Job No. 195345

April 24, 2024

Re: Response to CGS Review Comments dated August 4, 2022 and October 26, 2022
Lots 1-39, Falcon Meadows at Bent Grass, Filing No. 4
El Paso County, Colorado

FALCON MEADOWS AT BENT GRASS FILING NO. 4

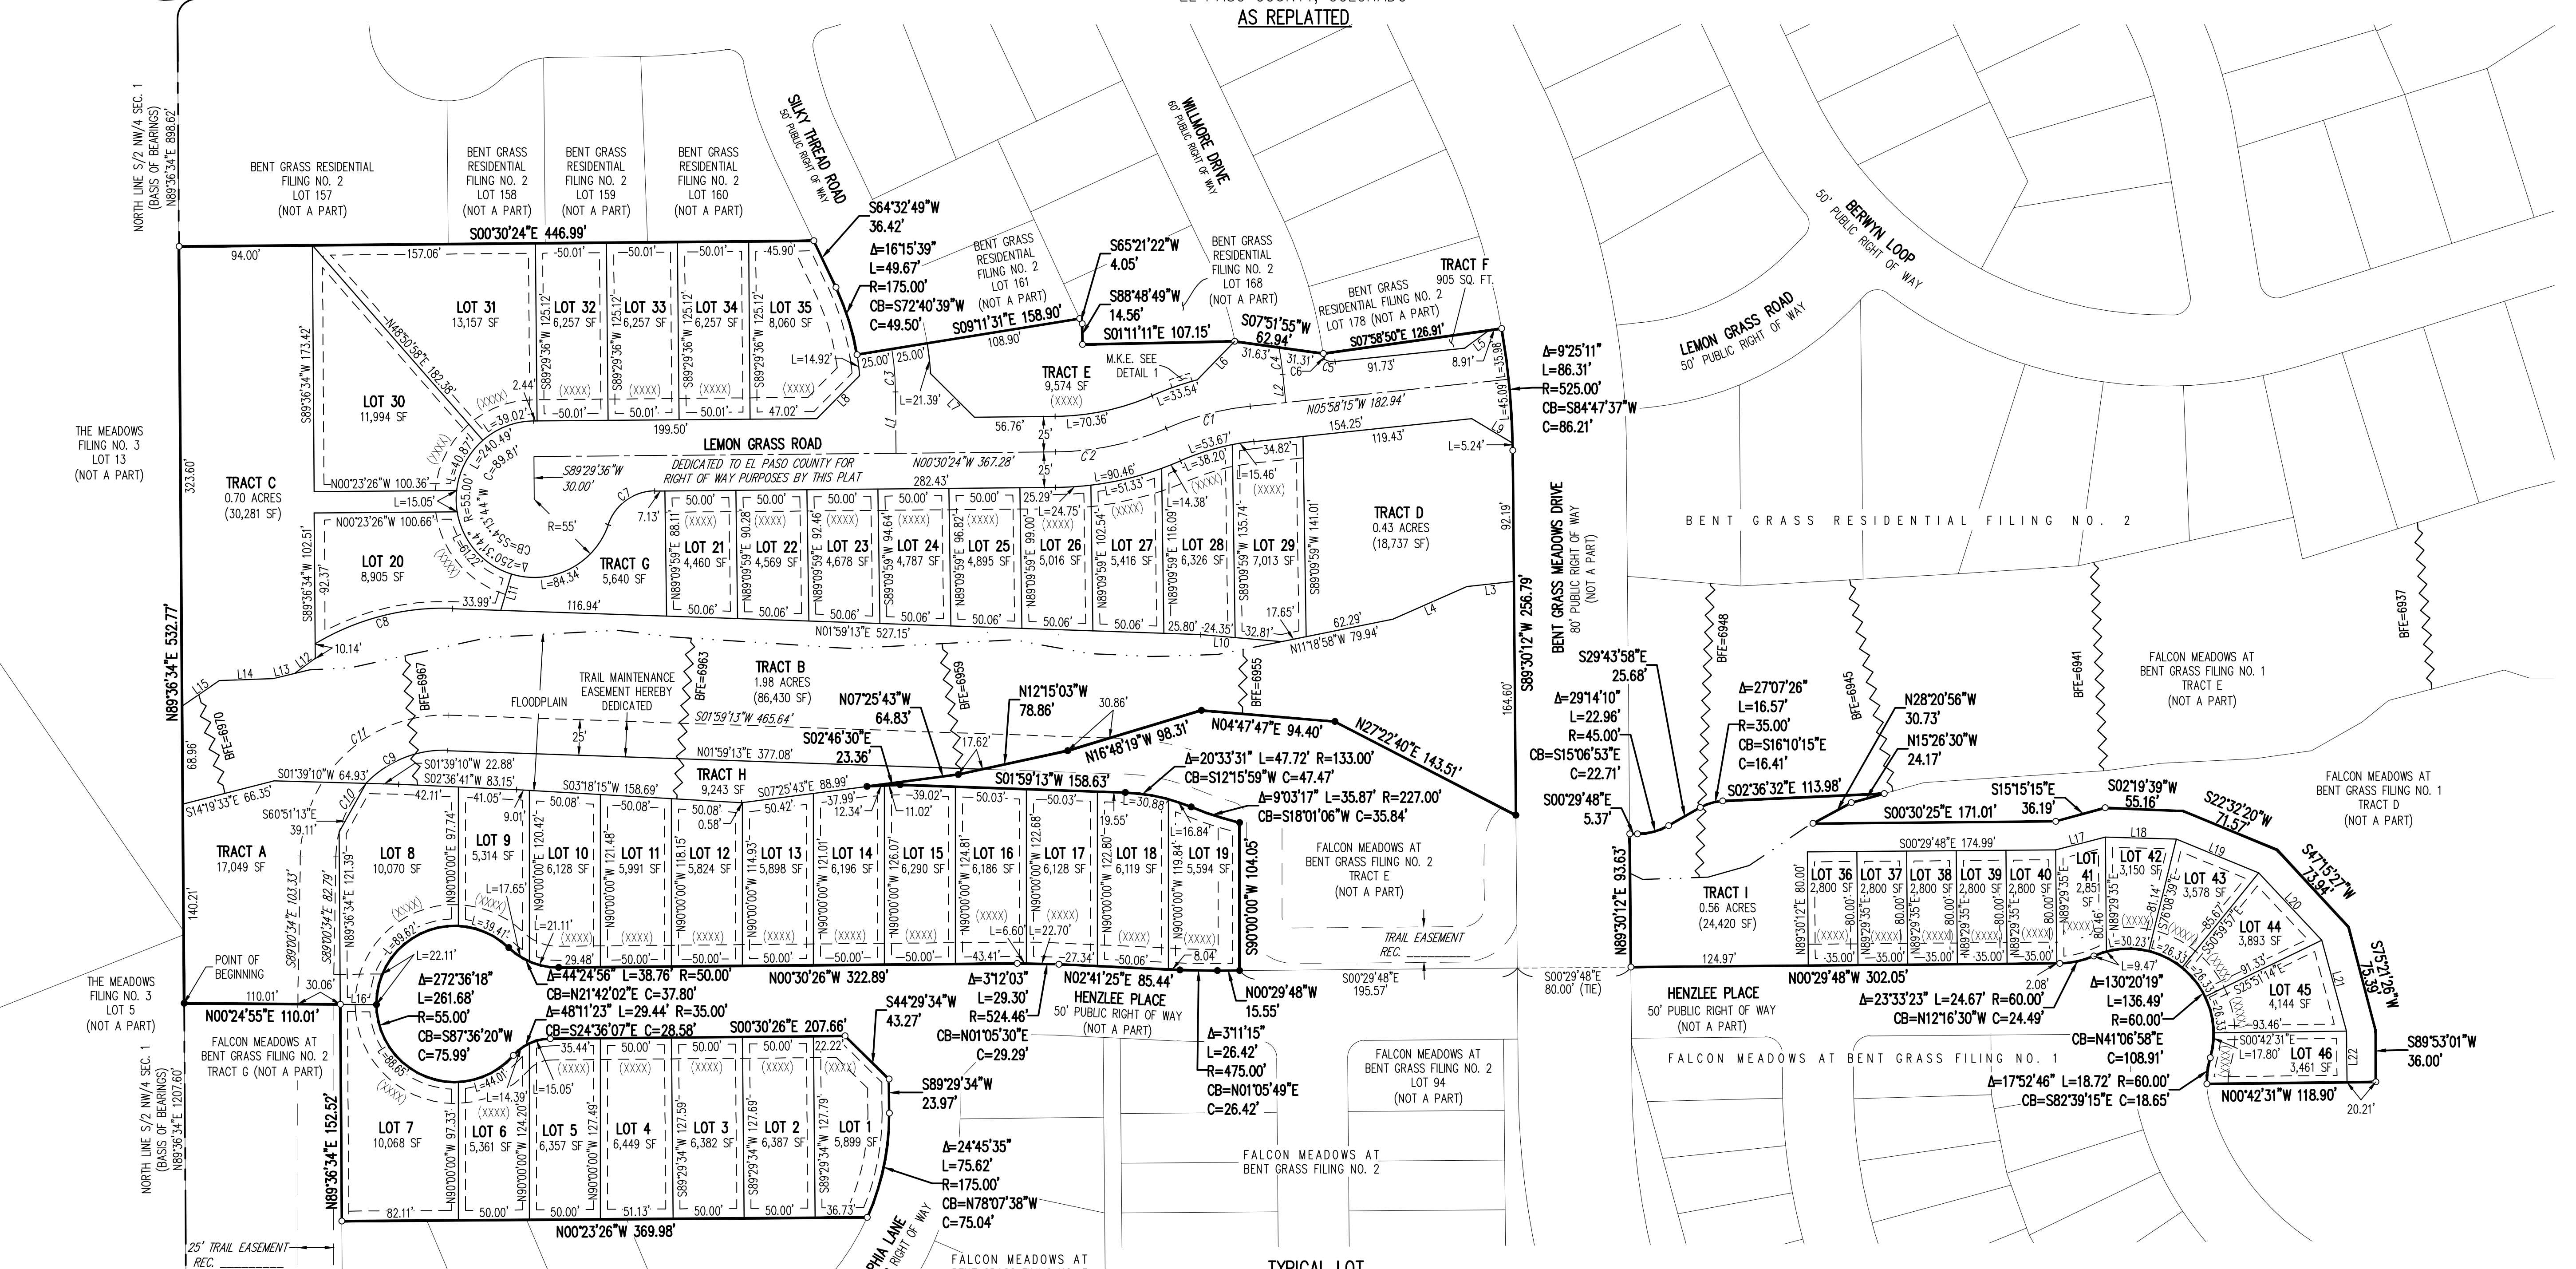
Also, the Geologic Hazards note on the final plat (Galloway, October 4, 2022) states, "The builder has agreed to restrict construction to non-basement foundation types in areas where groundwater is anticipated to be shallower than 14 feet below ground surface. The soils and geology study did not restrict any lots in Falcon Meadows at Bent Grass Filing No. 4 due to shallow groundwater." However, the December 3, 2021, report by RMG does not investigate or include any reference (or updates) to Filing No. 4. Therefore, our previous recommendation remains valid.

As noted above, all 39 lots in Filing No. 4 are to be stiffened slab-on-grade foundations with no below ground habitable or inhabitable space.

The plat note is to be updated to state "*The builder has agreed to restrict all construction in Filing No. 4 to non-basement foundation types*".
